09 October 2009

**RESPONSE TO DECCW LETTER OF 1 OCTOBER 2009 REGARDING THE  
PROPOSED DEVELOPMENT AT 35 WATER STREET, WAHROONGA**

Cumberland Ecology  
PO Box 2474  
Carlingford Court 2118  
NSW Australia  
Telephone (02) 9868 1933  
Mobile 0425 333 466  
Facsimile (02) 9868 1977  
Web: [www.cumberlandecology.com.au](http://www.cumberlandecology.com.au)

EXTENTS OF EXISTING BLUE GUM HIGH FOREST AREA SHOWN HATCHED

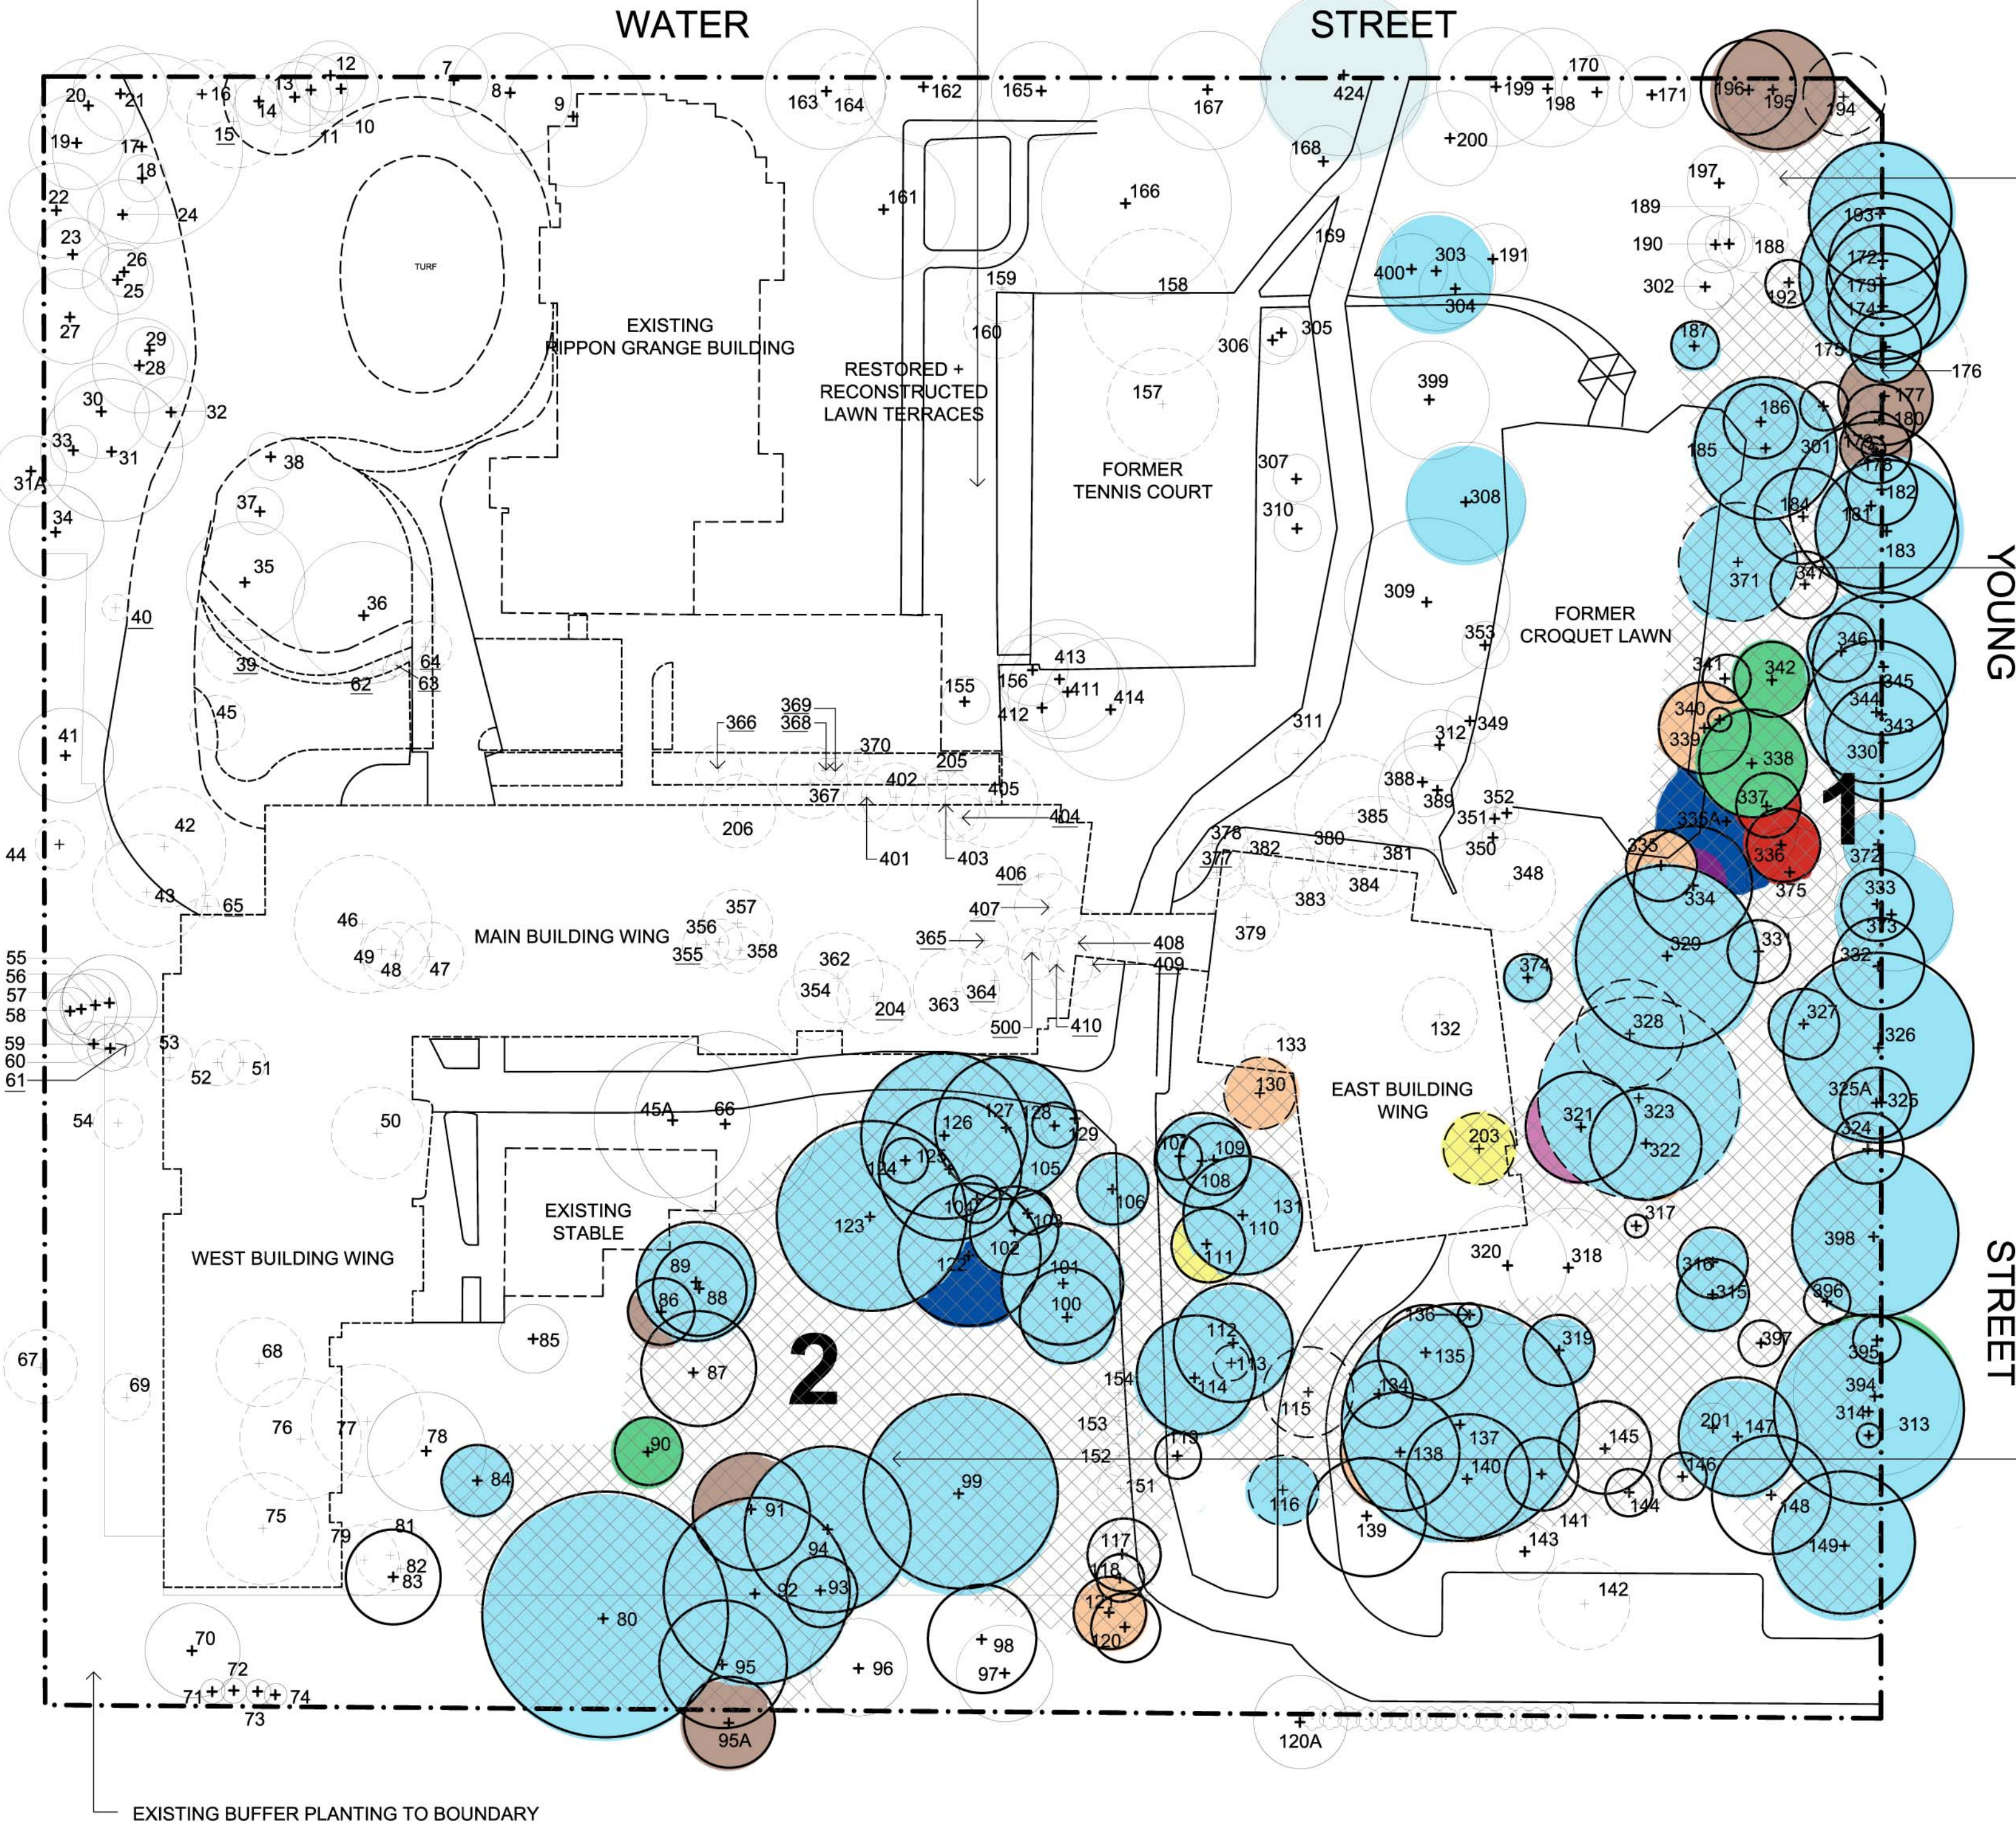
**DECCW has substantially increased the area mapped on site**, going well beyond the mapping of Smith that was accepted by the Land and Environment Court and adding approximately 40% to the area mapped as BGHF. The DECCW map:

- differs from the Smith mapping because it maps areas as BGHF regeneration based simply on the presence of some hardy grasses and herbs, **without canopy, even though DECCW acknowledges that the mapped vegetation “may not” currently comply with the Final Determination;**

- includes pathways and brick walls;
- includes elevated, landscaped garden beds;
- includes the croquet court, where the soils have been excavated and levelled and held in place by a 1.5 metre high retaining wall;
- includes essentially no Blue Gum trees.

It is manifestly unfair of DECCW to map such a large additional area of BGHF that goes well beyond that determined by the Land and Environment Court, when in DECCW's own words, such vegetation does not comply with the Final Determination for BGHF. No adequate data or justification has been provided to support this additional area mapped by DECCW.

## CORE BGHF AREA 1

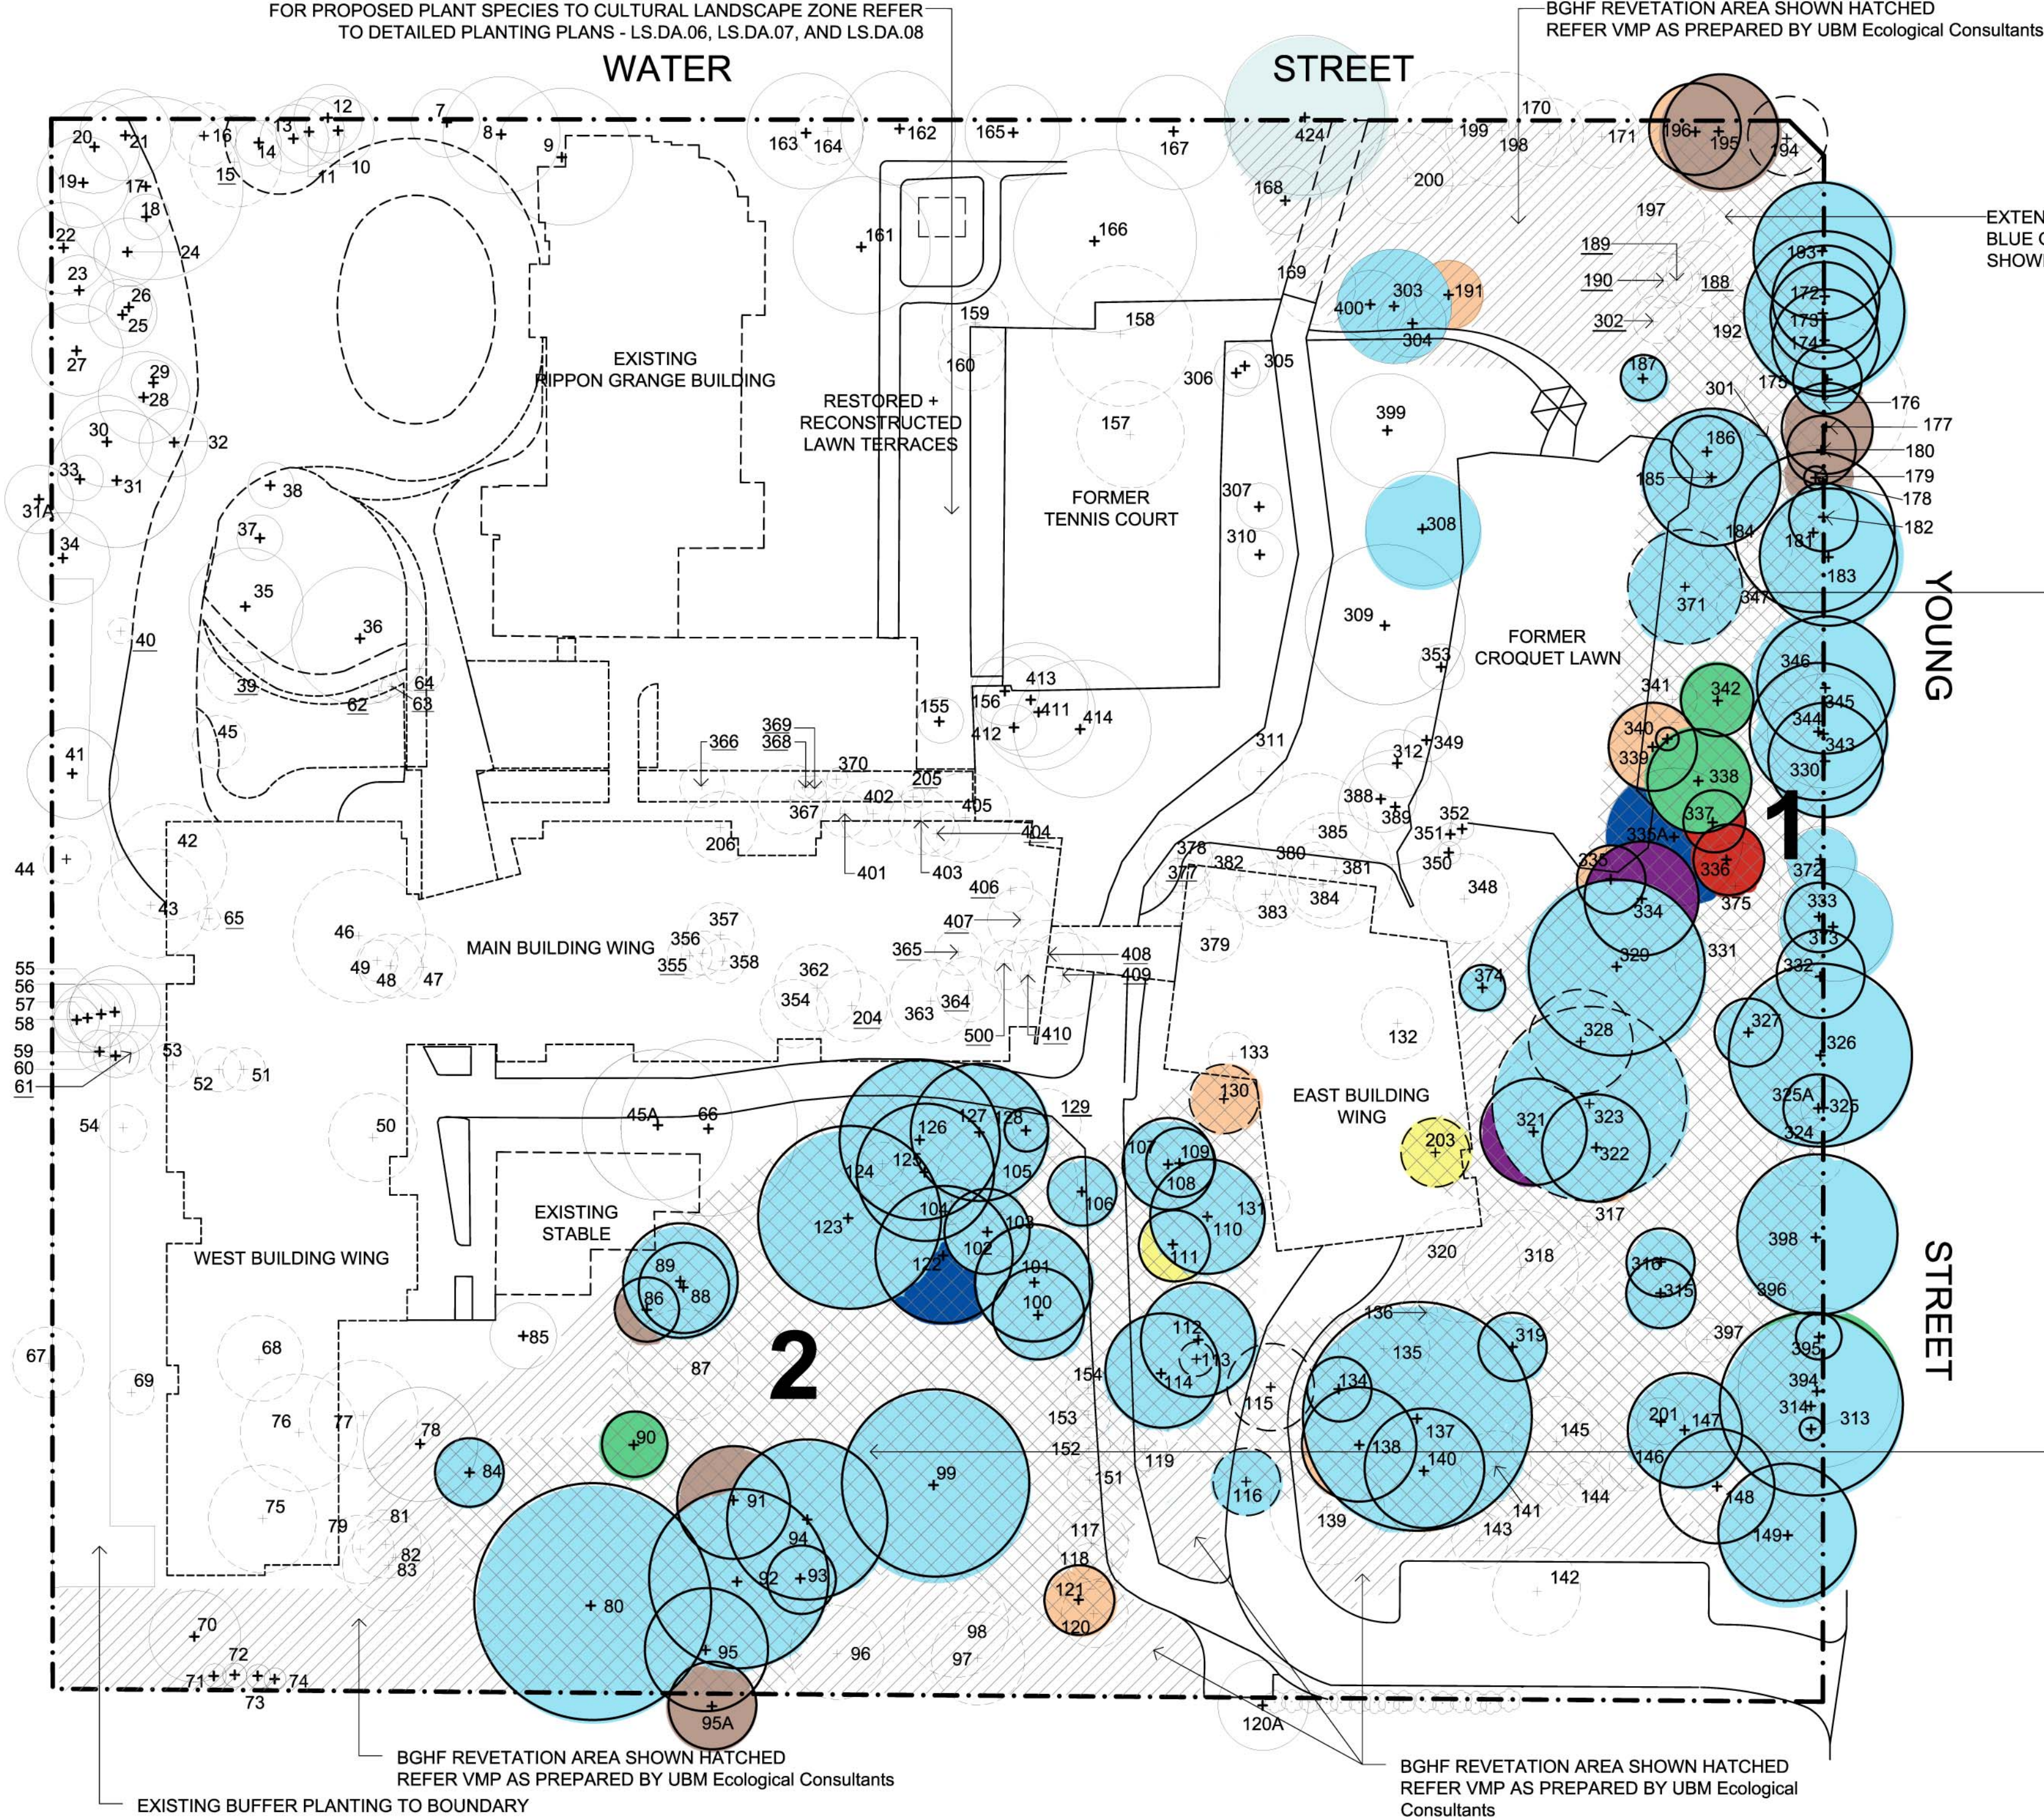
*The known extent of BGHF on the ground has been mapped, rather than the extent of the canopy. Therefore, the existing remnant is somewhat smaller, taking into account the lack of canopy trees of BGHF on the croquet lawn and lack of BGHF on the access path from Young St.*

- *Figure 2 includes a larger area of clearance around the East Wing and stables than was indicated in the CE mapping, to provide for an access path around these structures.*
- *Figure 2 includes 'additional regeneration areas'. These areas will be separated from the larger remnant areas due to pathways. Given these areas will be significantly affected by edge effects, it is considered unlikely that vegetation in these areas could be regenerated to 'BGHF', as indicated in the CE mapping. However, they may provide some ecological land buffer values.*

This "justification for mapping" is flawed. The first sentence states that the known extent of BGHF on ground has been mapped, rather than the extent of the canopy. Yet, in the previous section of the letter, DECCW states that such areas "may not" be BGHF:

The comment about separation of remnants seems to imply that areas will be separated due to pathways. This is not true as pathways will at most be only several metres wide. According to DECCW's own policy (eg BioBanking) remnants within 100 metres are effectively regarded as having connectivity. The narrow paths in question will not separate these areas.
